# LSC Responses to EPC TIS Redline Comments

## Colorado Center Habitat for Humanity Traffic Impact Study (LSC #S244050) April 24, 2024 PCD File No. SP243<sup>1</sup>

Figure 7
Existing plus Site-Generated Traffic, Lane Geometry, Traffic Control, and LOS

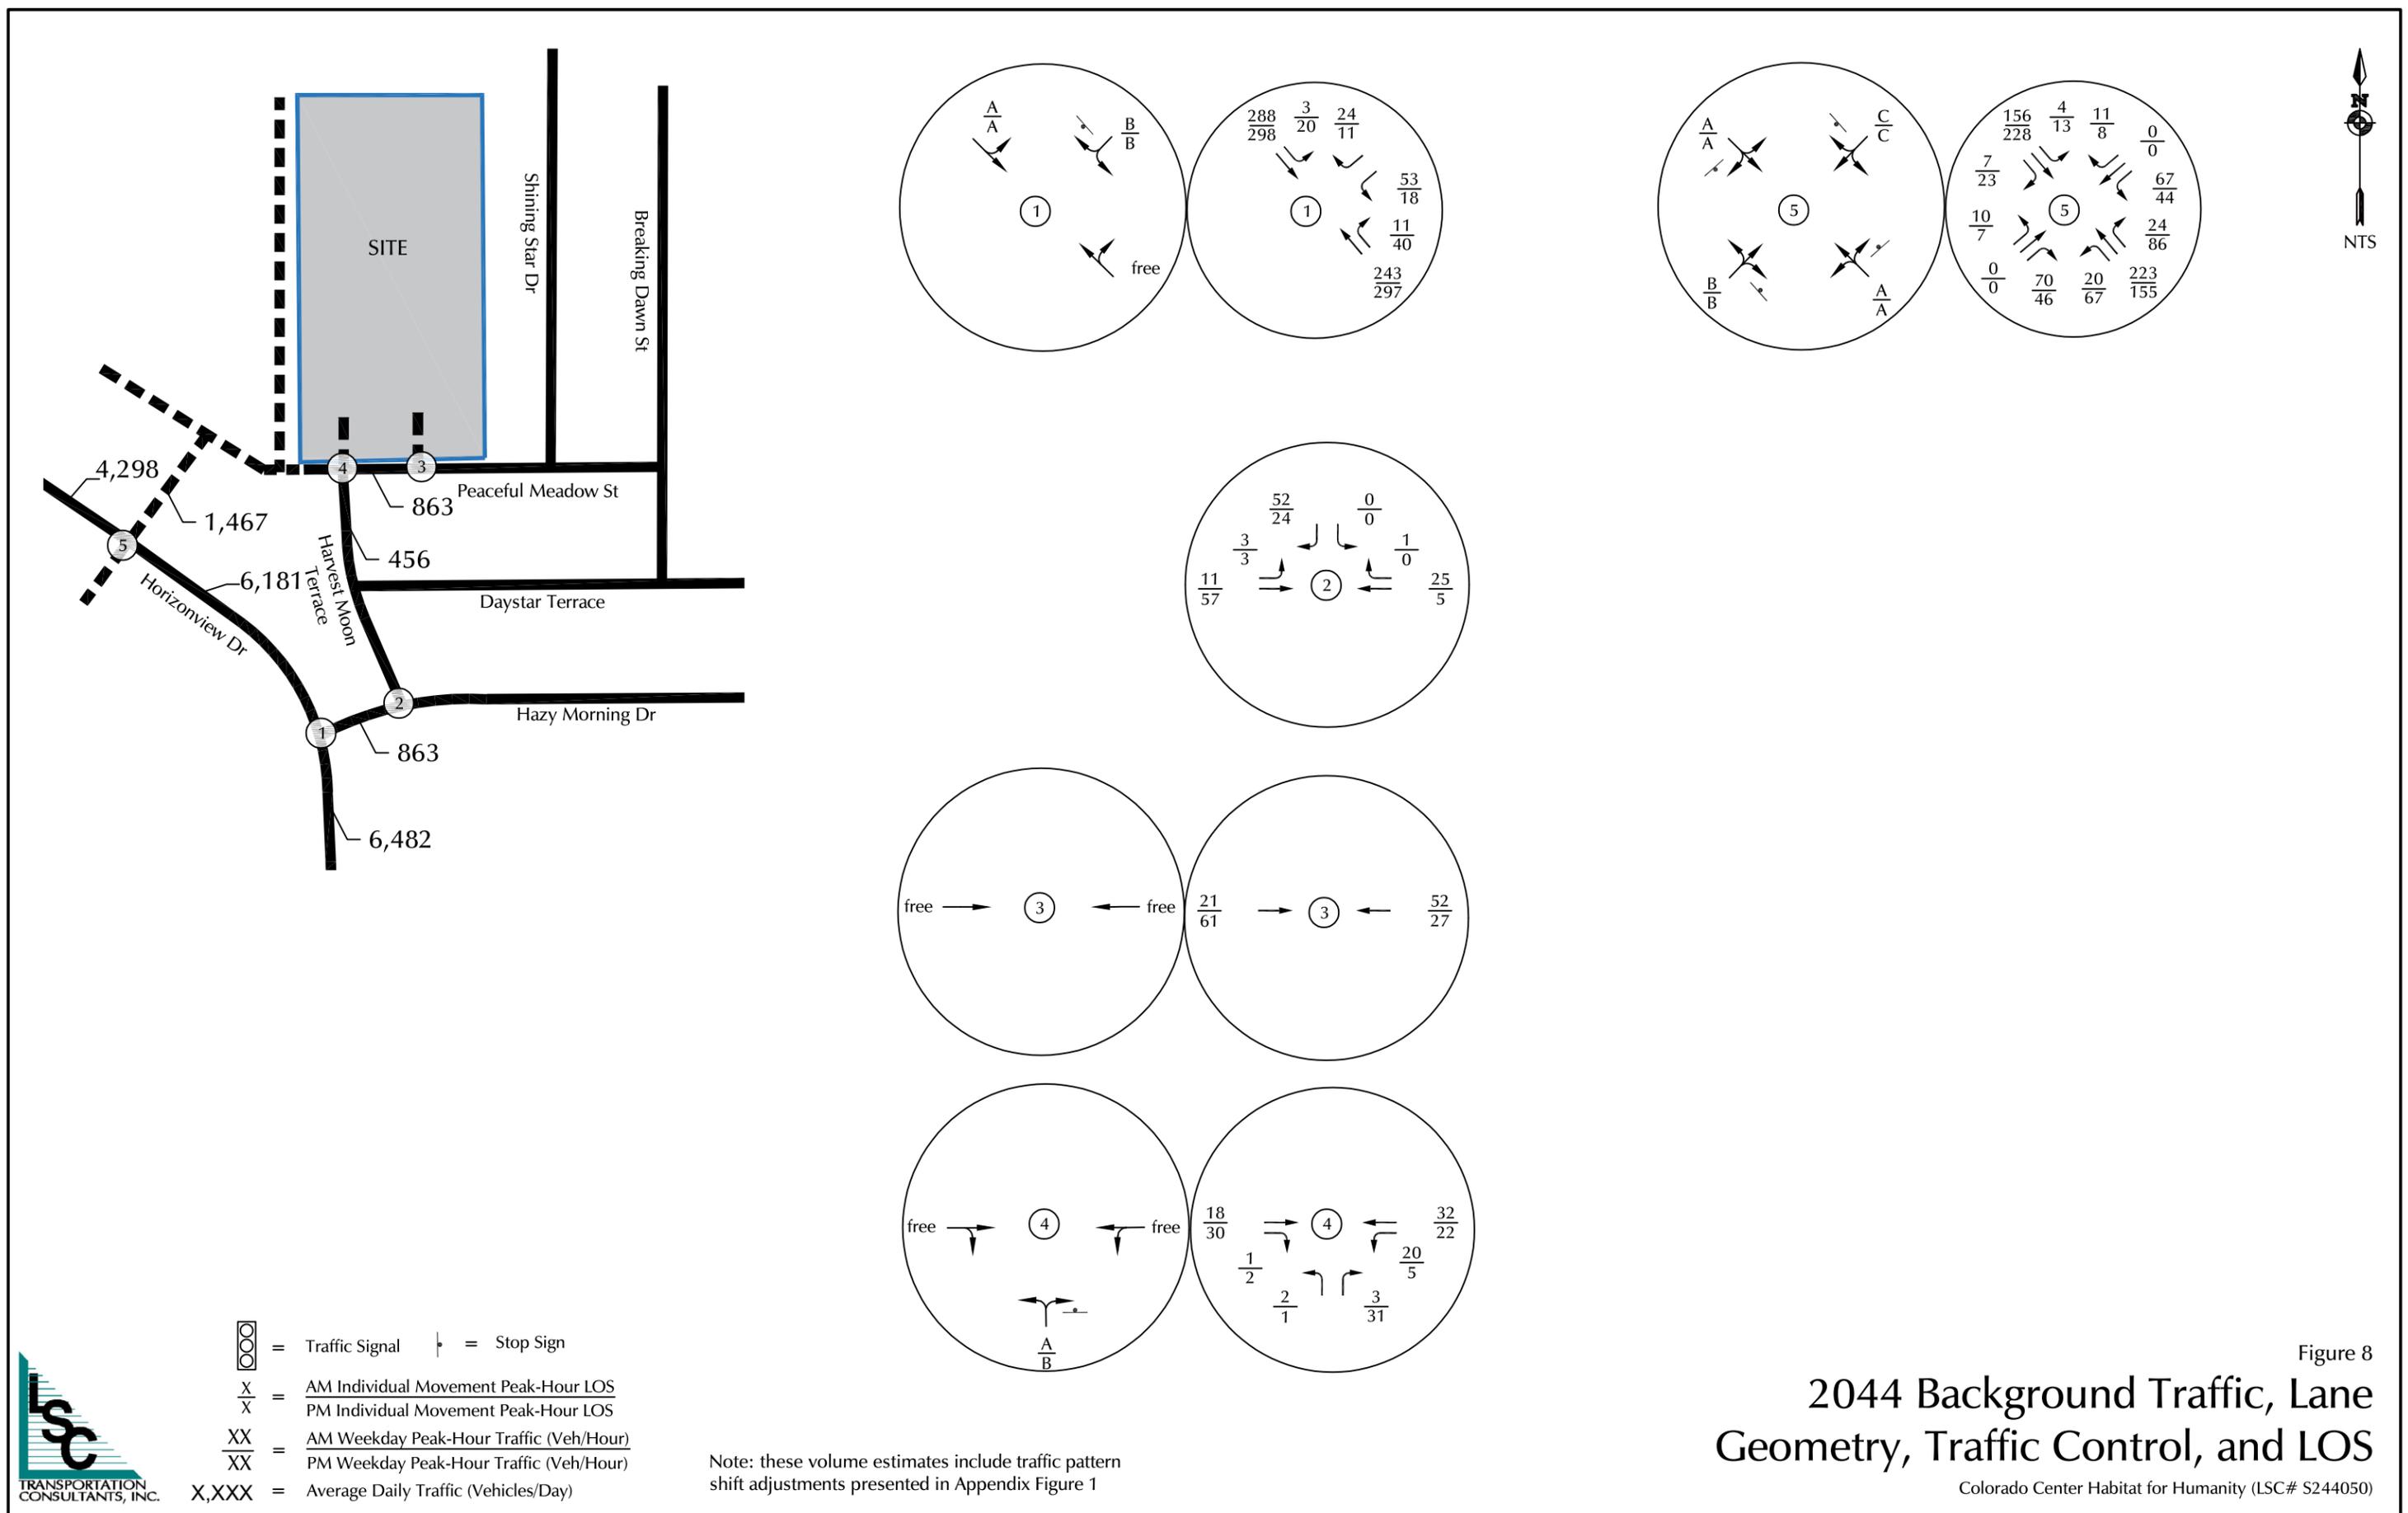
Figure 7 indicates that existing and proposed traffic volume exceed the thresholds for exclusive turn lanes

Figure 7 indicates that existing and proposed traffic volume exceed the thresholds for exclusive turn lanes

Exceeds threshold for turn volume

turn lanes are required per the volumes shown at each of these highlighted movements. Please address and revise the narrative accordingly.

LSC Response: This comment has been addressed in the narrative of the updated report. Note: I also provided a response to the related comment on Figure 7.

LSC Response: This comment has been addressed in the updated report. A few items to note:

- 1) The PM peak-hour eastbound-left turn at intersection No. 3 shown as "65" has been corrected to show "5." The "65" was a typo.
- 2) Regarding the comment regarding the PM northbound right-turn movement on Horizonview at Hazy Morning, the County ECM turn-lane-threshold volumes do not apply. This is a city intersection and the city "Traffic Criteria Manual" applies and is referenced in the TIS.
